CITY OF ALBUQUERQUE

May 22, 2024

**Re: Event Center
1611 Airtech Ct SE
Site Plan
Architect's Stamp 5-8-24 (N15D017)**

C-1

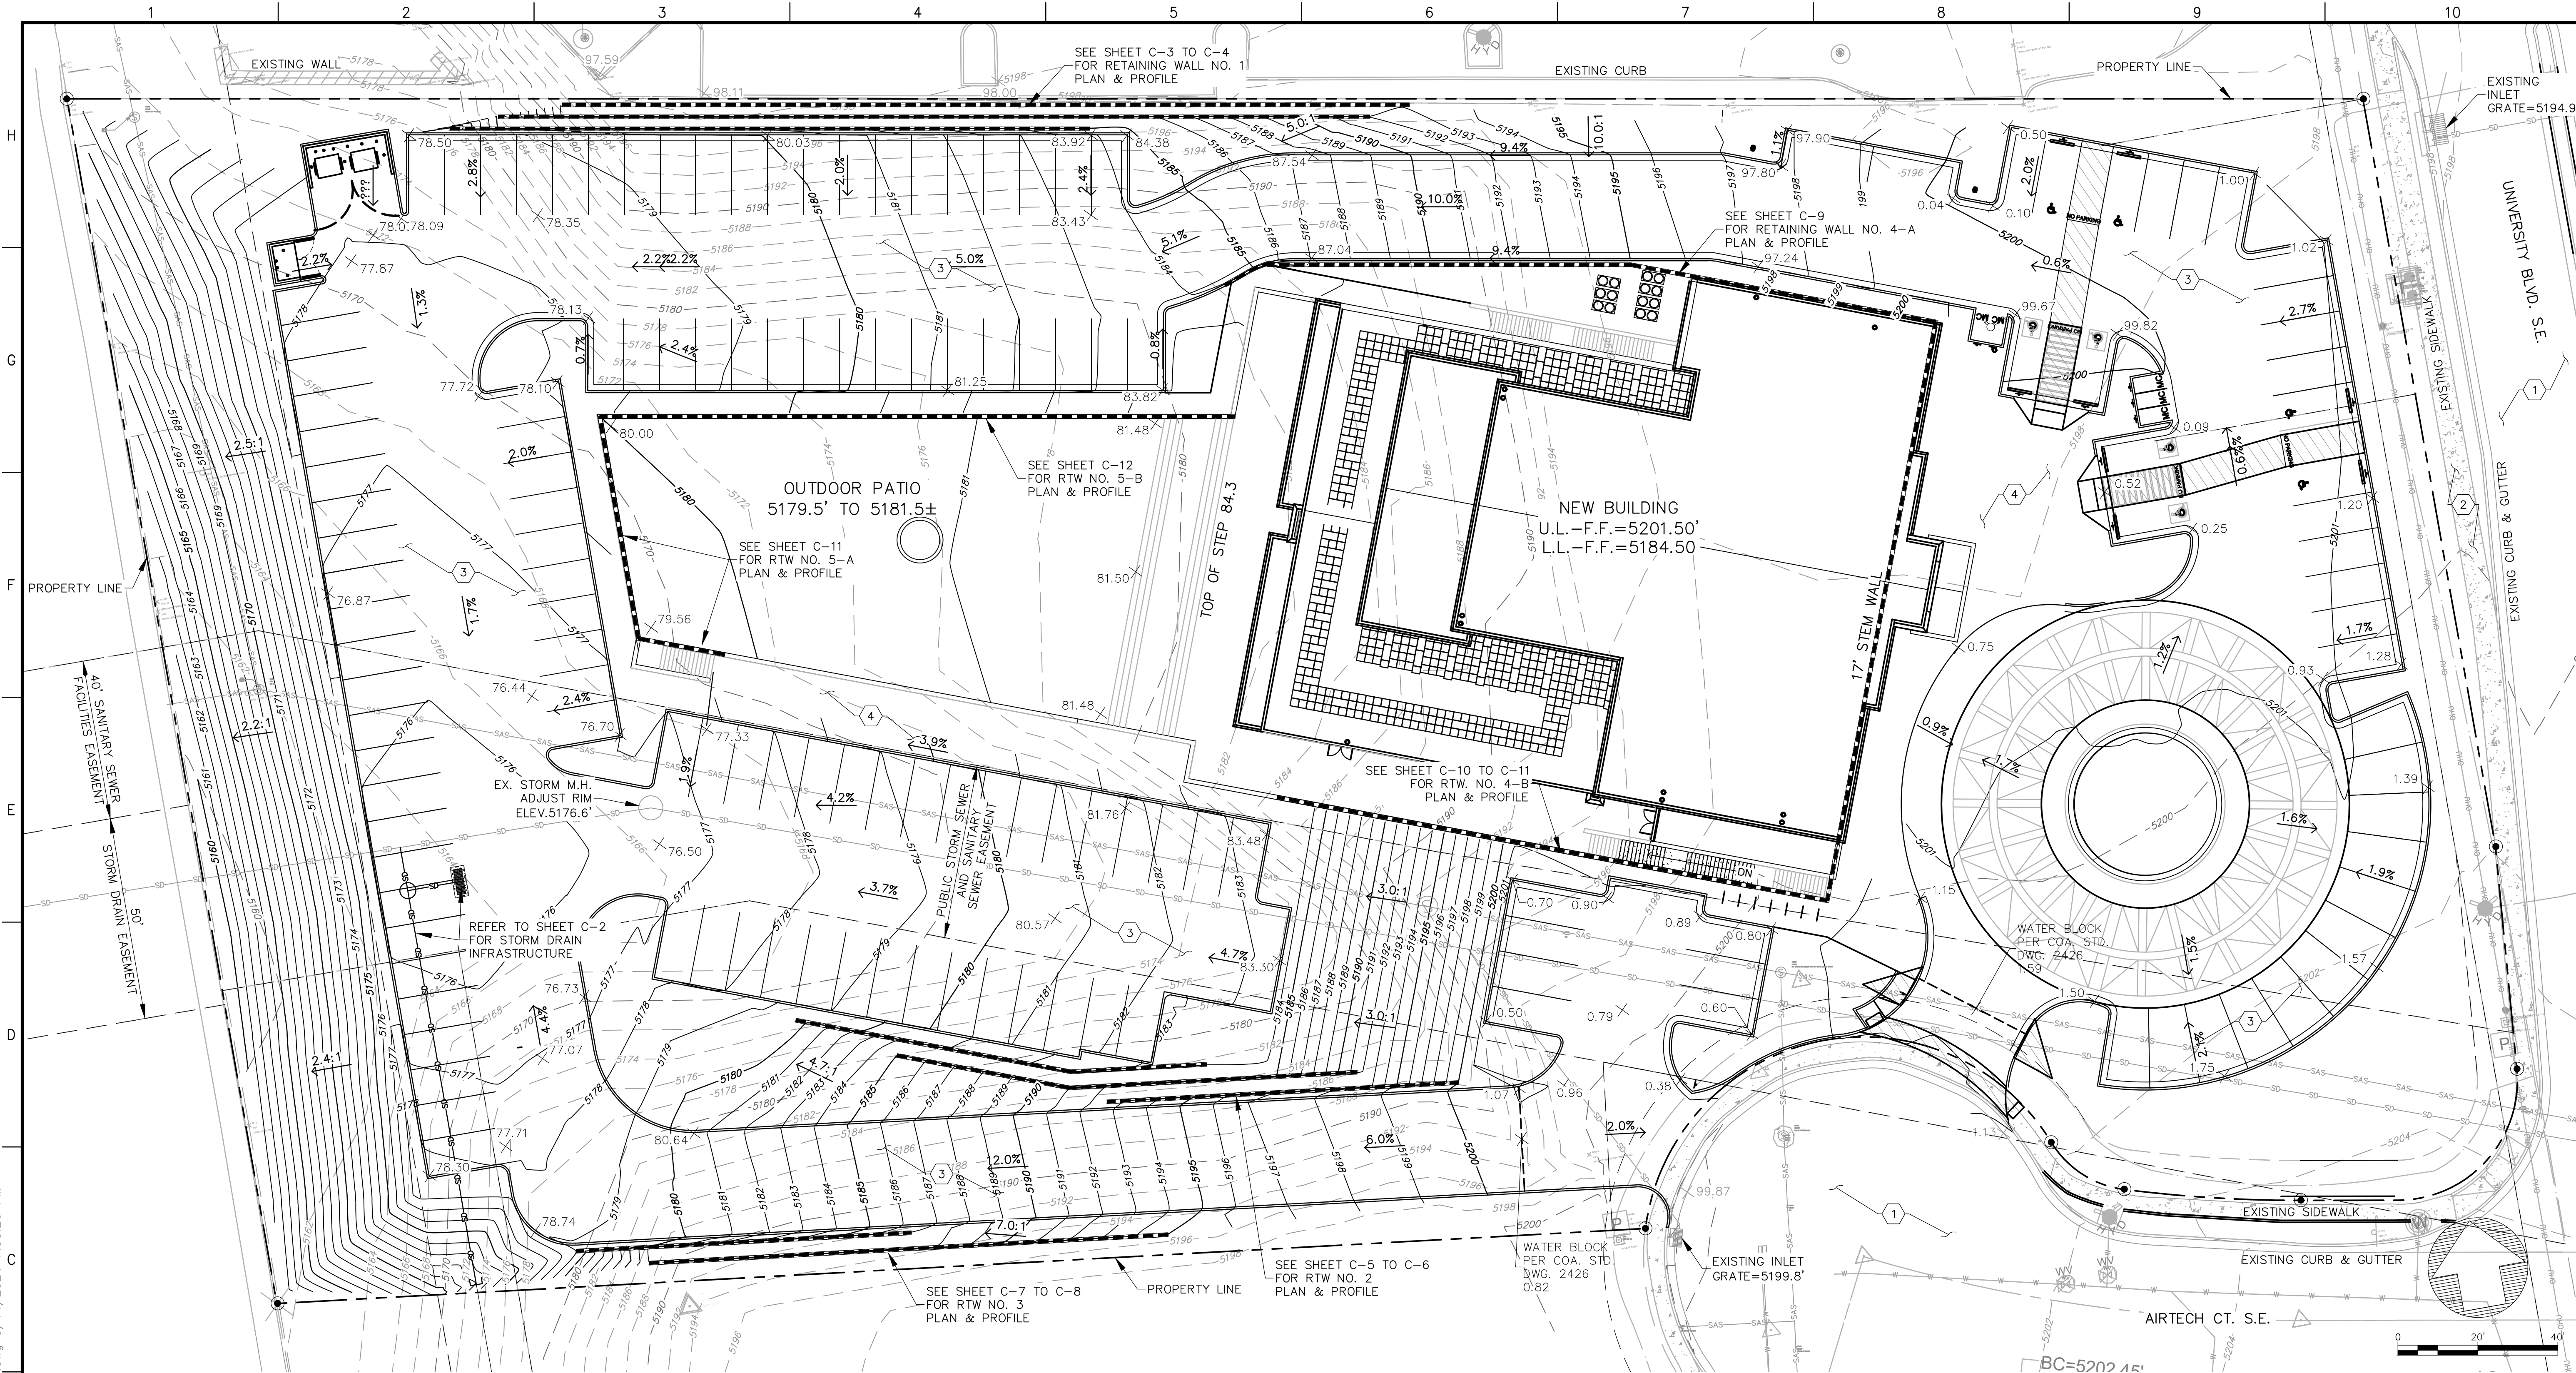
10. Do the perpendicular lines cross the ramps at the east and west end indicate change in slope? It would help with visibility if the south ramp flattened 50 ft or so from the flowline in the cul-de-sac. **Flattening of the slope 50 ft or so from the flowline was not addressed. The grading plan shows the change to 2.0% further from the flowline than this plan.**

DATE	3/29/2024	SHEET	G3A
SCALE:

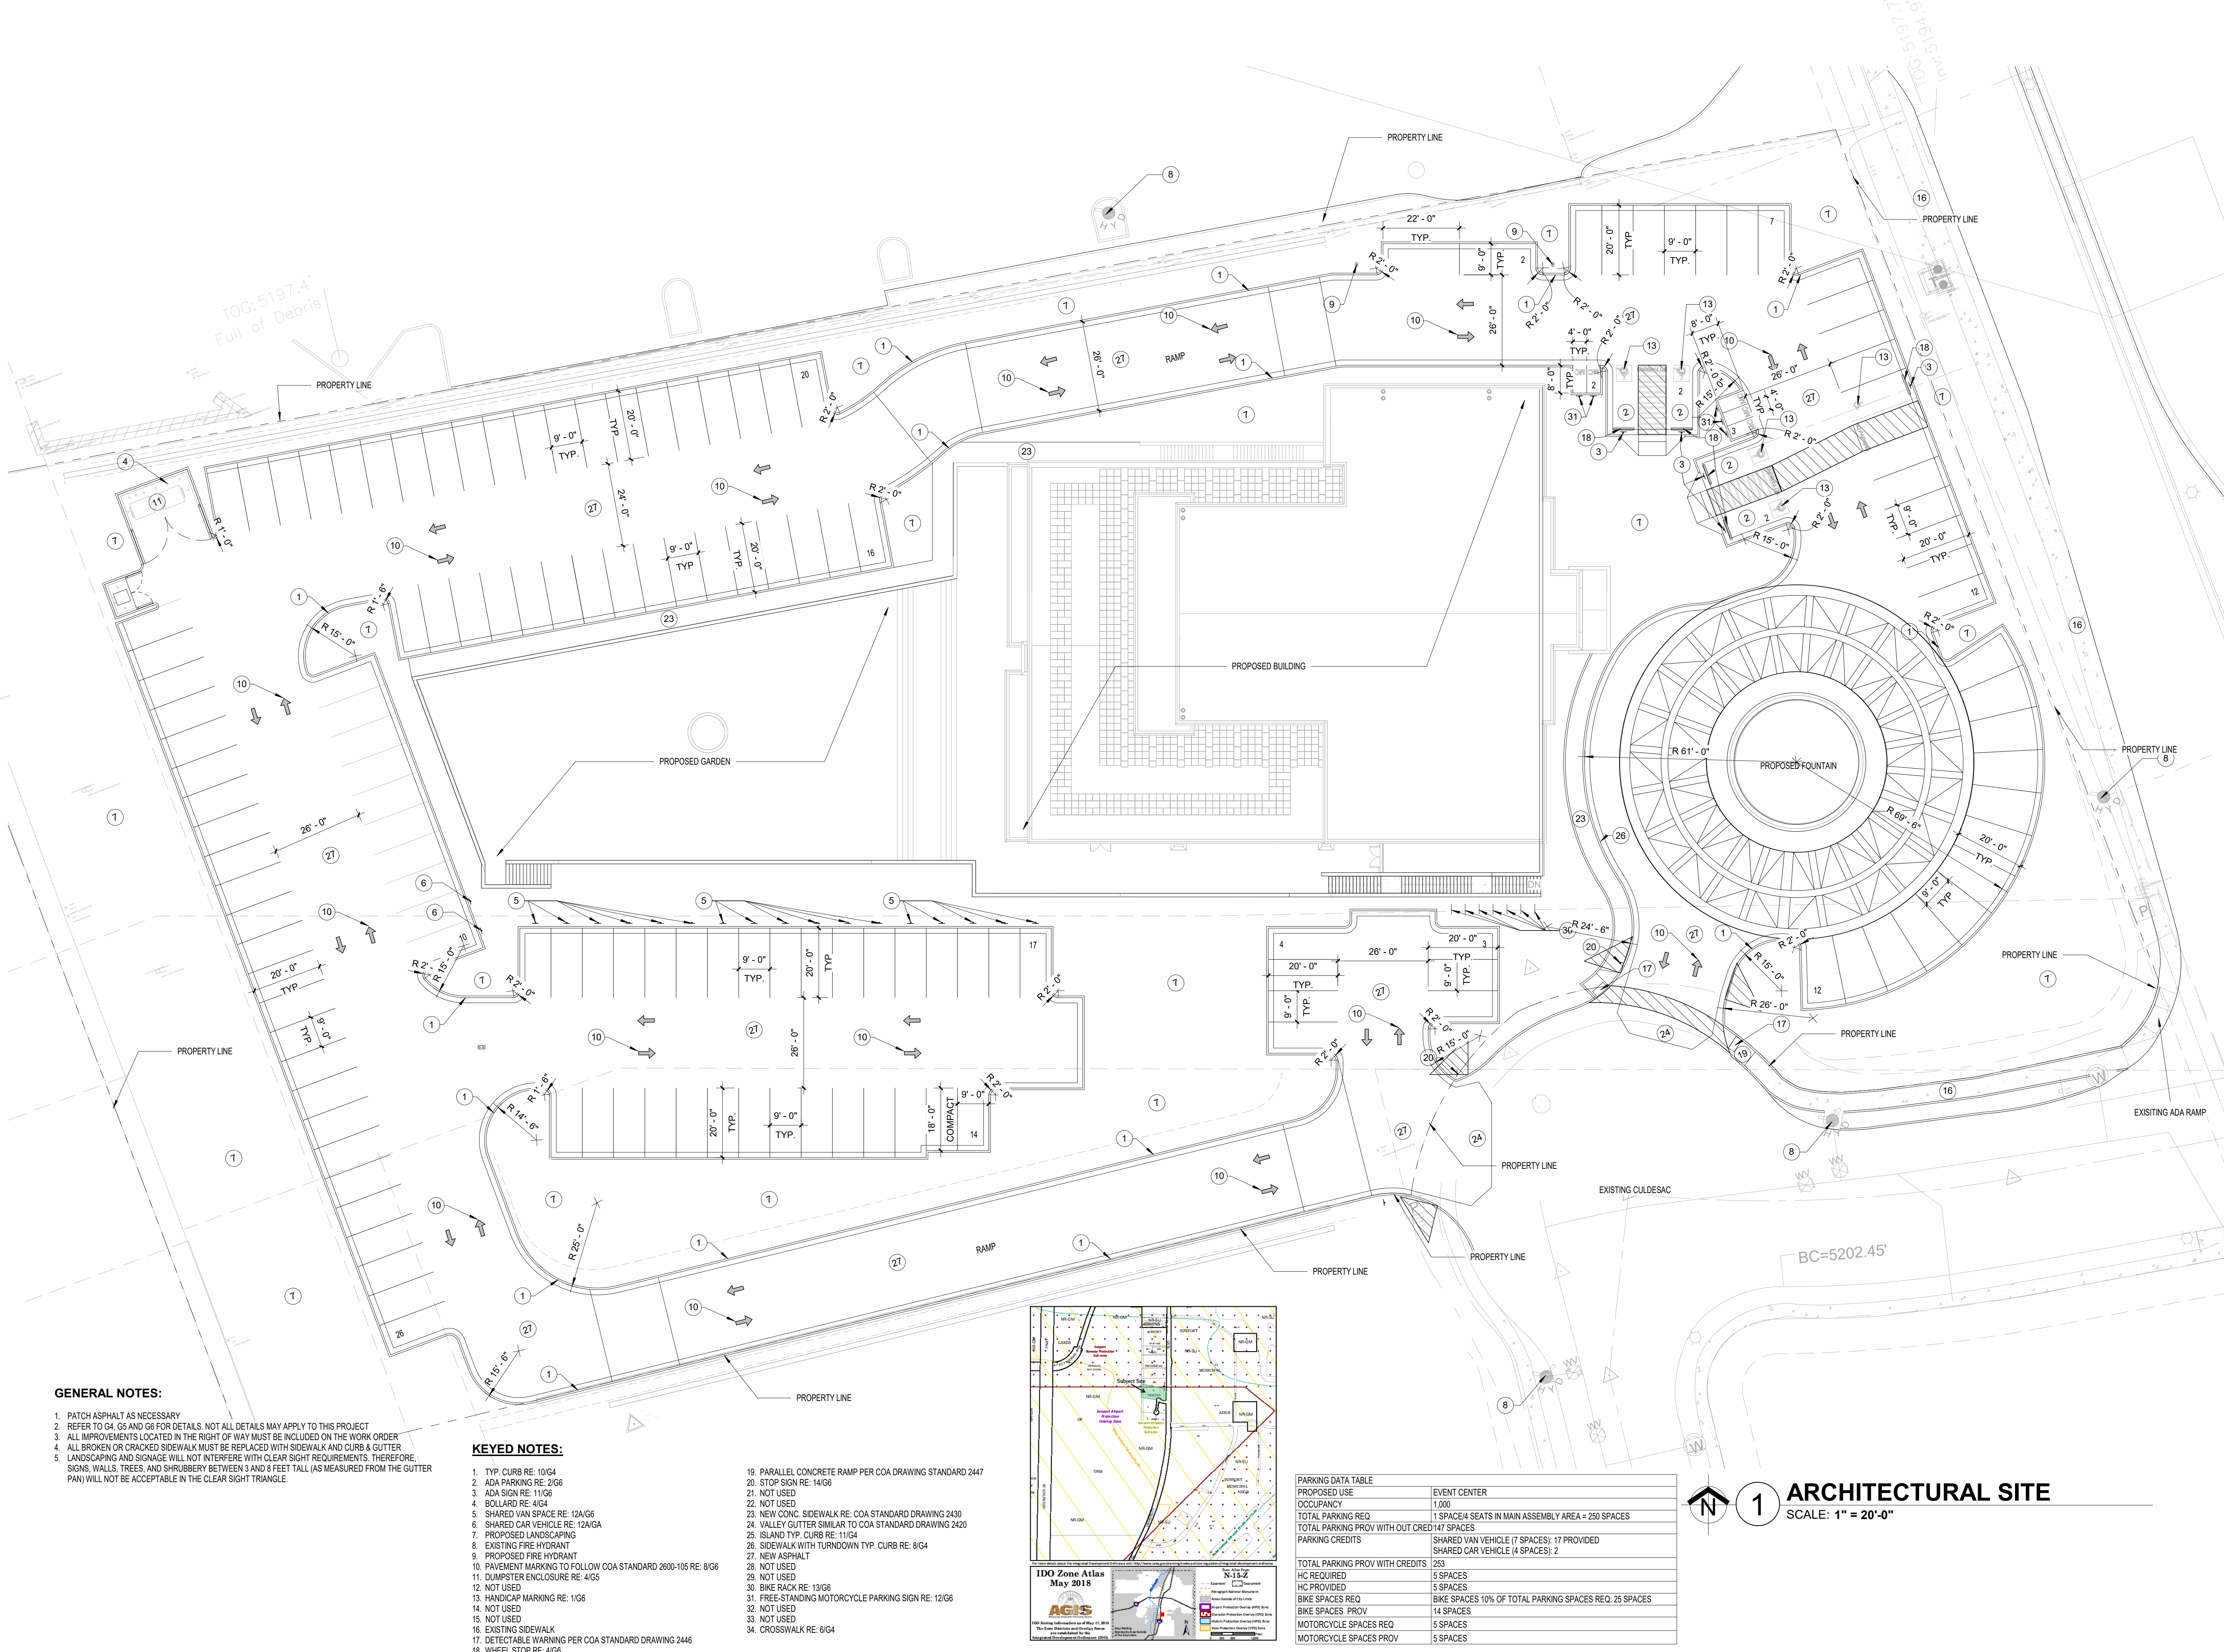
1. There should be 8 accessible parking spaces when the total number of parking spaces provided is 101-300 (2015 NM Accessible Parking Checklist). In addition, 2 van spaces should be provided. **Revise the parking table as necessary**, add three more accessible parking spaces and show which 2 accessible spaces will be designated as the Van Accessible spaces.

2. Where are the Shared Car Vehicle spaces? **Revise Keyed Note 6. Change "12A/GA to "12A/G6".**
3. The two "Compact" spaces should have "COMPACT" pavement markings in the rear of the space. **Pavement markings are shown in the middle of the space.**

4. Show the drainage inlet on the plan that is located in the west/northwest area of the cul-de-sac. The gutter transition begins 5' on either side of the inlet. It appears you may have to relocate the inlet, if approved by Hydrology. This will require a drainage submittal to Hydrology and a Work Order for the relocation. It may also require reconstructing the cul-de-sac to change the low point to the new inlet location. **Show the Inlet/catch basin. This was discussed with Hydrology and the inlet will most likely need to be relocated. If it is to be relocated, this plan can show the inlet with a note "Inlet to be relocated" or similar.**

5. The patterned surface in comment #2 above, overlaps the curb and gutter in a few places. Probably should reduce the diameter of the patterned surface. **Response addressed paving material, rather than the overlap.**

6. Is there a curb or similar (e.g. apron) to prevent drivers from crashing into the fountain? **Response was "There is a curb", but there should be a Keyed Note on the plan for the curb, most likely Keyed Note 1.**

7. Provide/show the 6' accessible path from a ROW to the building. **Width dimension not shown on plan for sidewalk and path.**

8. The sidewalk and landscape area appear to merge at the building entrance and there is no accessible path from the accessible spaces to the front door. **The ramps shown north/northeast of the main entrance need to have 5'x5' landing at the top. Recommend removing or reducing the size of the landscape area to accommodate accessibility.**

9. What are the slopes of the "ramps" on the north and south sides of the building. Max is 5%. I noticed the site drops approx. 30 ft from the cul-de-sac to near the west property line. **Thank you for providing ramp slopes. However, they are too steep: reduce to 8.0% max. I discussed this site with Hydrology. The retaining walls may not be approved as shown. This site may be too steep for his size of a project. Provide Hydrology approval.**

11. It appears you have the 5' minimum keyway distance in the small parking lot south of the building. Please add a dimension. **The dimension provided is 4'-5". It appears there is space to increase it to the required 5'.**

12. **Since the concrete section shown on detail 6/G4 can't be built in the ROW at the drive entrances and it is unusual to paint pavement markings in this area, Keyed Note 34 should be removed from the drive entrances.**
